9 February 2018

Planning Application WA/73/17/OUT Land East of Wandleys Lane Fontwell

Drawing Issue Status					
INDICATIVE - FOR INFORMATION					
LAND EAST OF WANDLEYS LANE A27 / A29 WEST ROUNDABOUT JUNCTION GEOMETRY					
Client					
WELBECK STRATEGIC LAND II LLP					
Date of 1st Issue 29.09.17		Designed JHJ	Drawn MJB		
A3 Scale 1:500		Checked GH	Approved GH

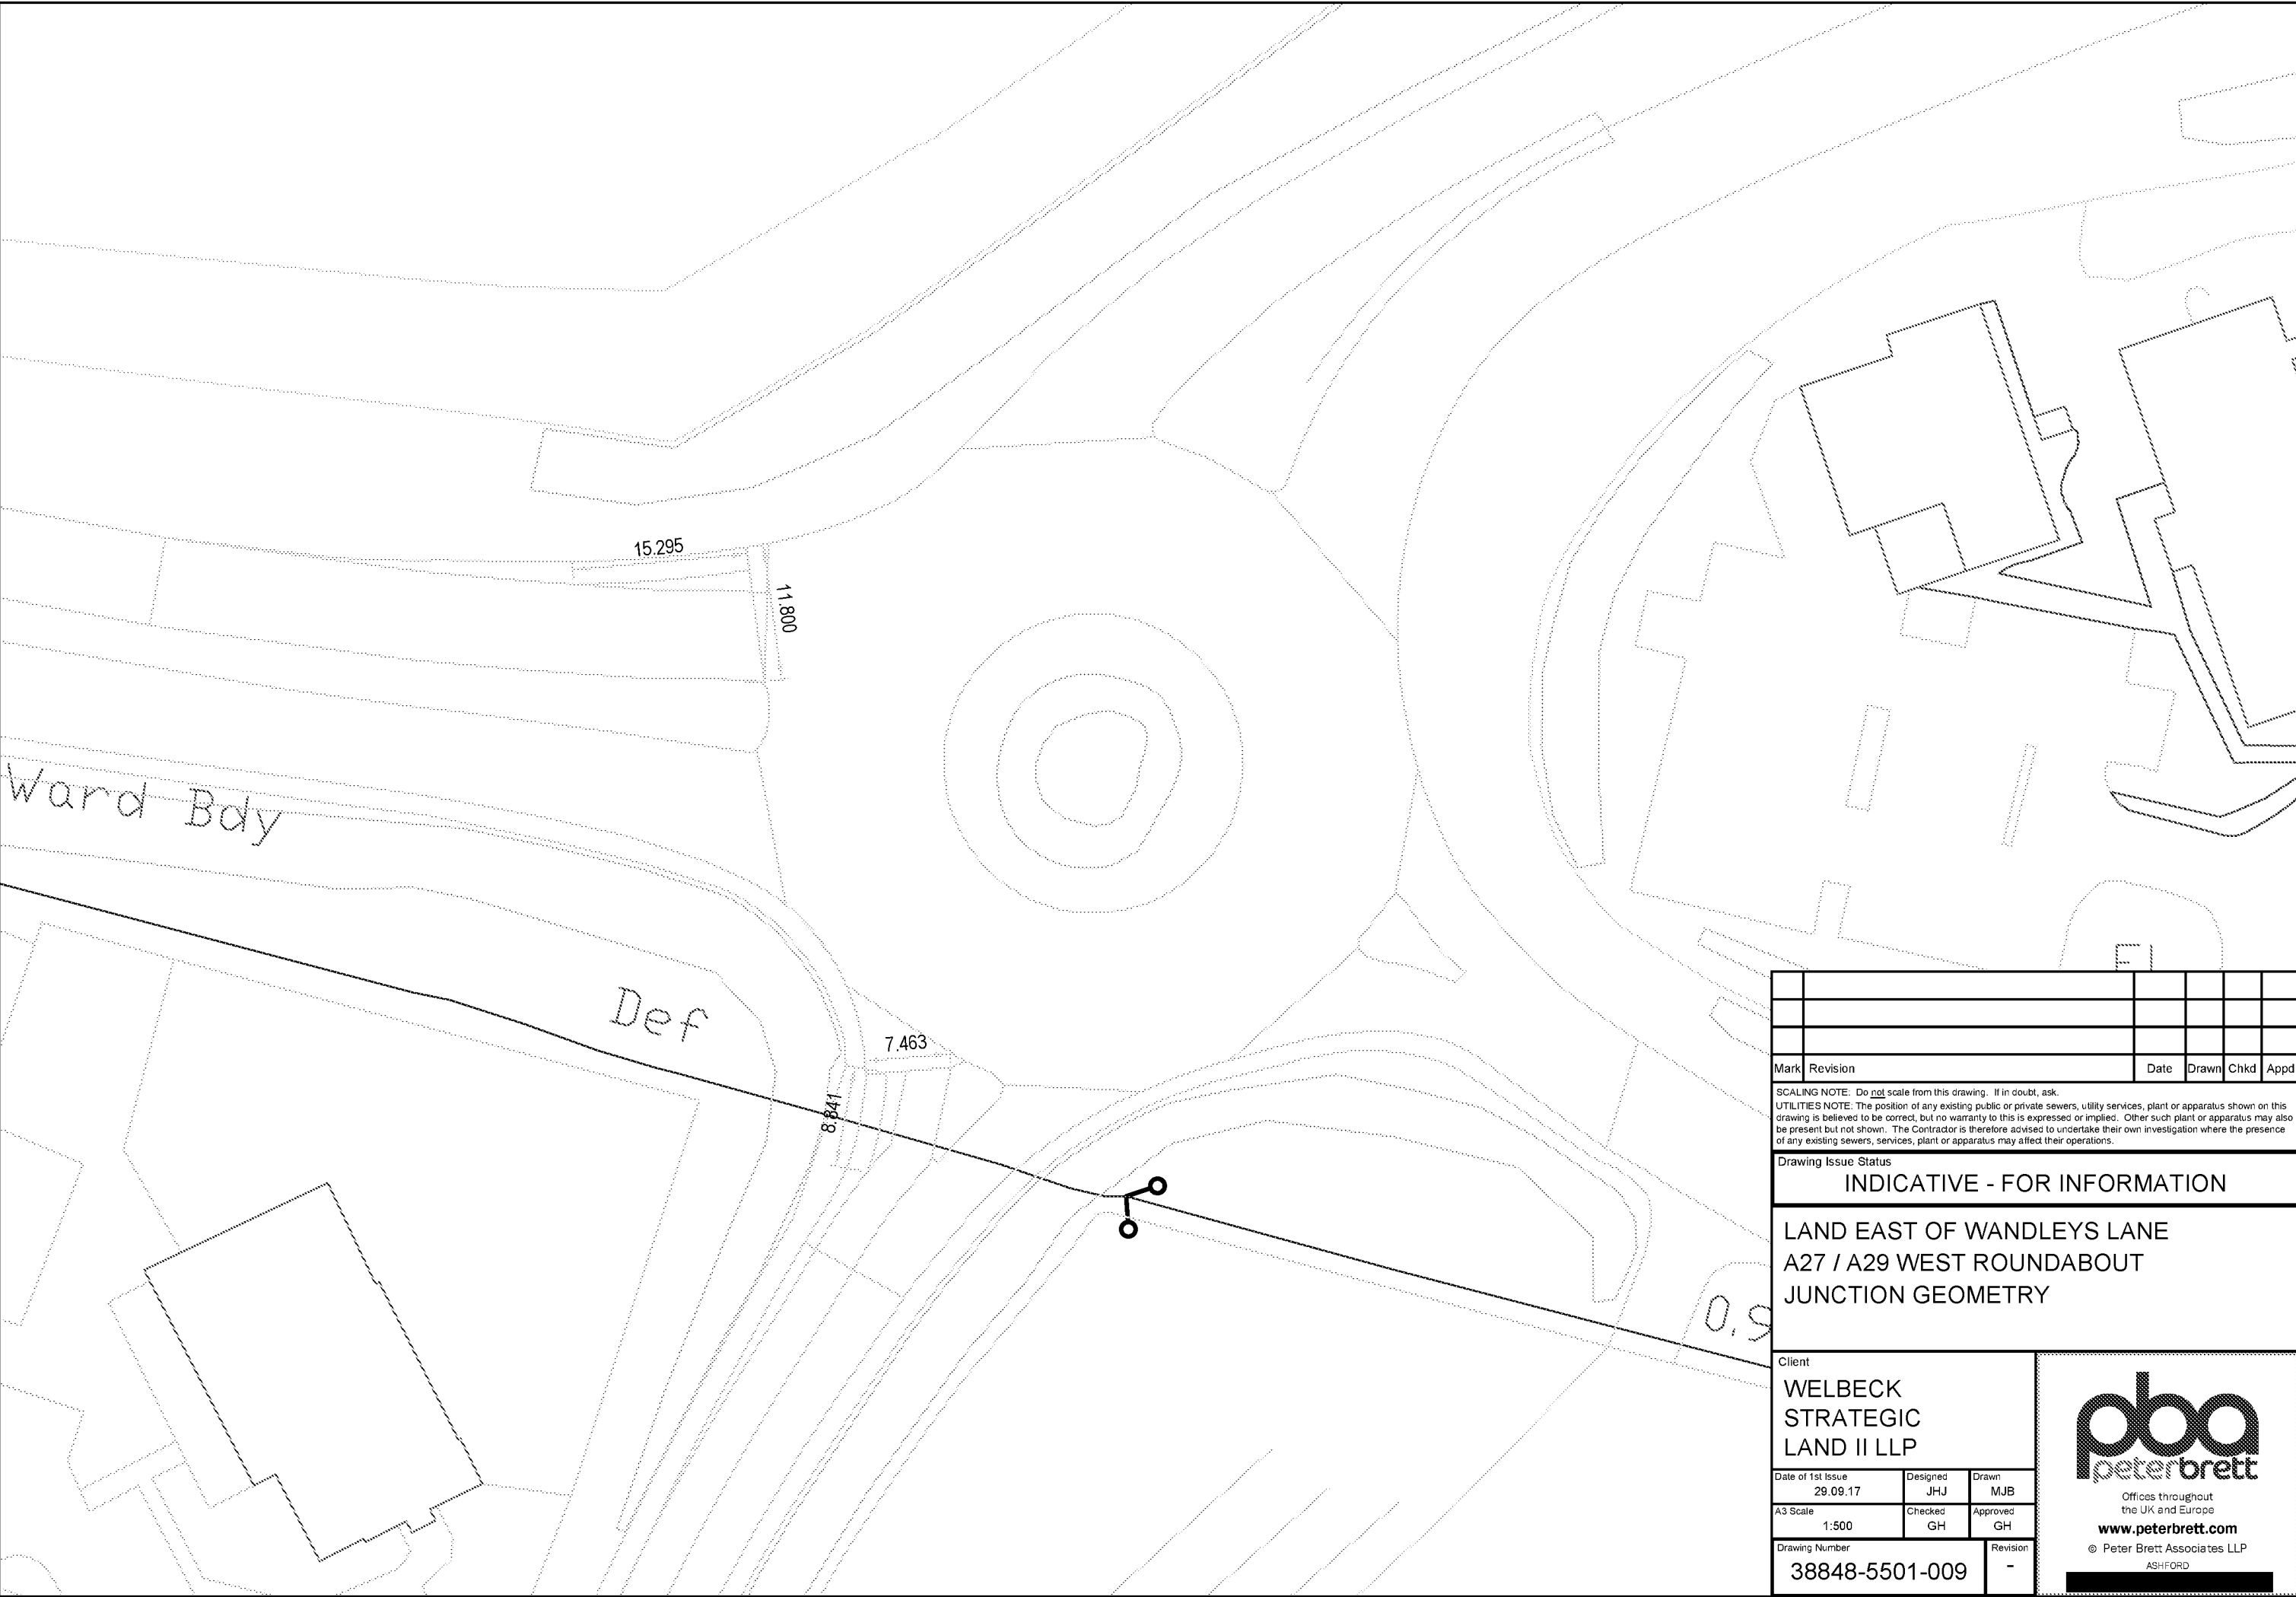
The latest Indicative map appears to relate to the highway from the proposed development to the junction of Wandleys Lane with West Walberton Lane. I have already made comment on footpaths and traffic particularly during construction stage in page 2 of my letter of 8 November 2017 and consider that the changes do not satisfy my concerns.

I would also like to add that I fear that the increase in volume of traffic in the area from both the development and the proposed improvement to the A27 will exacerbate the present problem of access from the Old Arundel Road to the outside lane of the south carriageway of the A27 before reaching the roundabout to go north on the A29 or east on the A27. At peak time I fear that the traffic will be at a standstill between the junction and the roundabout and at other times there will be a safety hazard weaving between lanes over the short distance between the junction and the roundabout.
